# CITY OF ALBUQUERQUE

November 18, 2013

**Re: GAHH Relocation and Tenant Improvements, 4900 Menaul Blvd NE  
Temporary Certificate of Occupancy – Transportation Development  
(H17-D110)**

No.	Description	Date
20_1225	CAD DWG FILE: DWL-NM_RESTORE	
	DRAWN BY: B. RAEL	
	CHECKED BY: R. BURTON	
	SHEET TITLE: TRAFFIC CIRCULATION PLAN

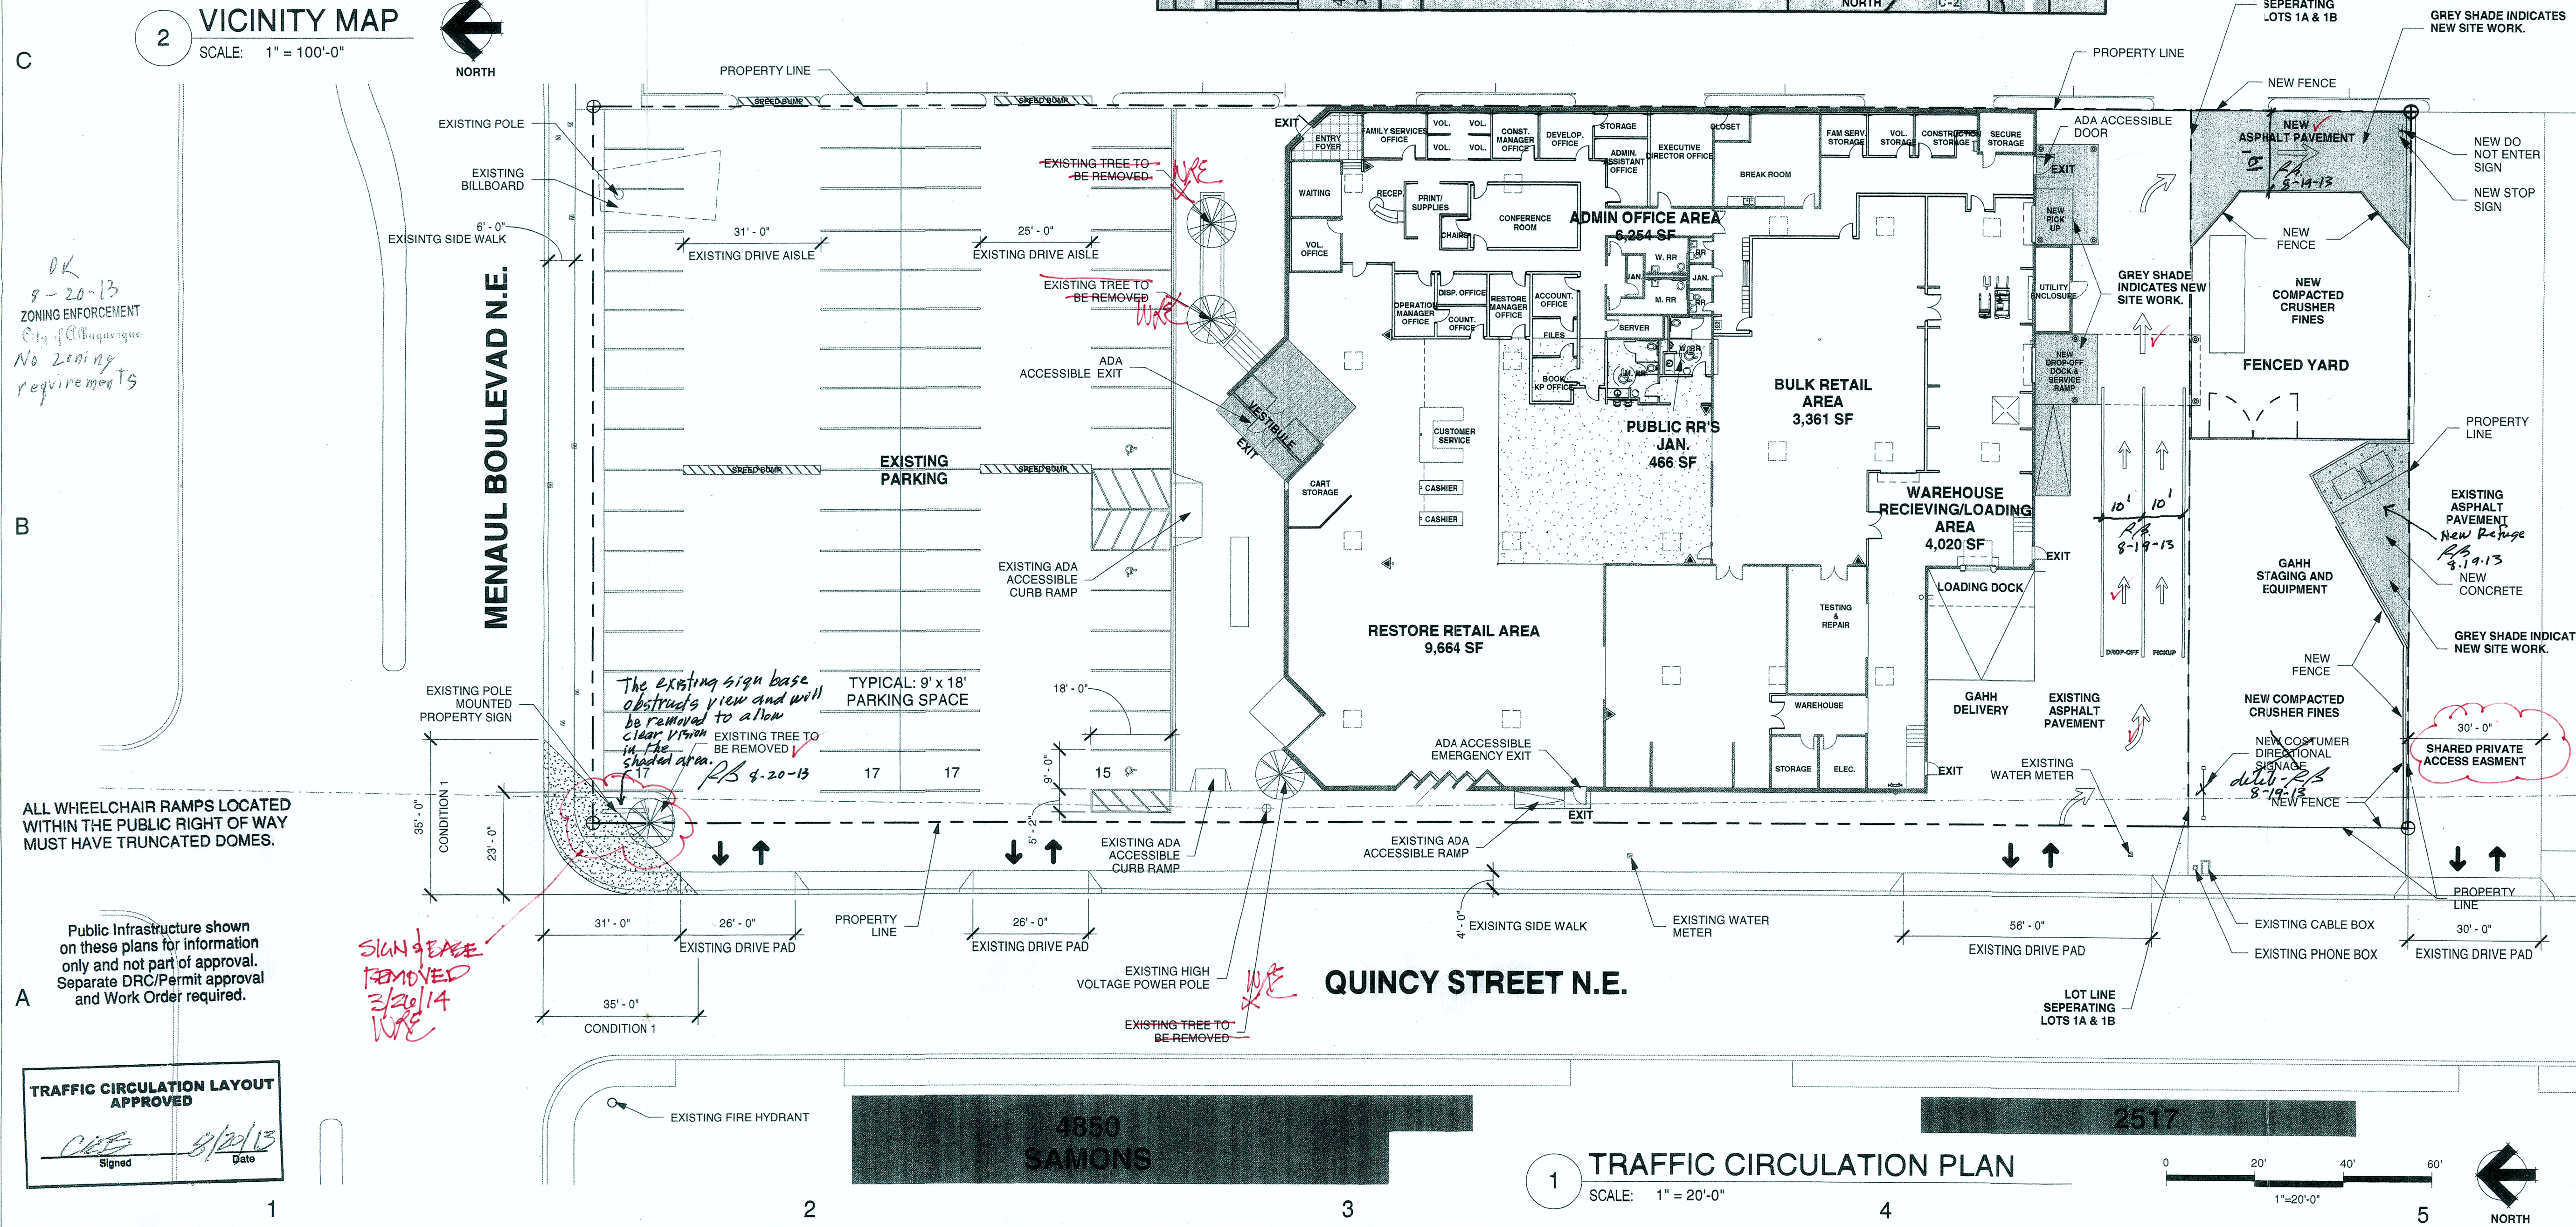
- The existing sign located at the corner of Menaul and Quincy, including the pedestal, must be removed.
- Signing and striping of the drop off area south of the building must be completed. At this time, compacted crusher fines and/or base course may be used to tie into the existing 30-foot wide shared access easement, with the understanding that asphalt pavement will be placed at a later date.
- Encroachments into the City of Albuquerque right of way will be addressed (see email dated 11-07-13 for additional information).
- A full certification including the approved plan with all appropriate red-lines, must be provided for permanent certificate of occupancy.
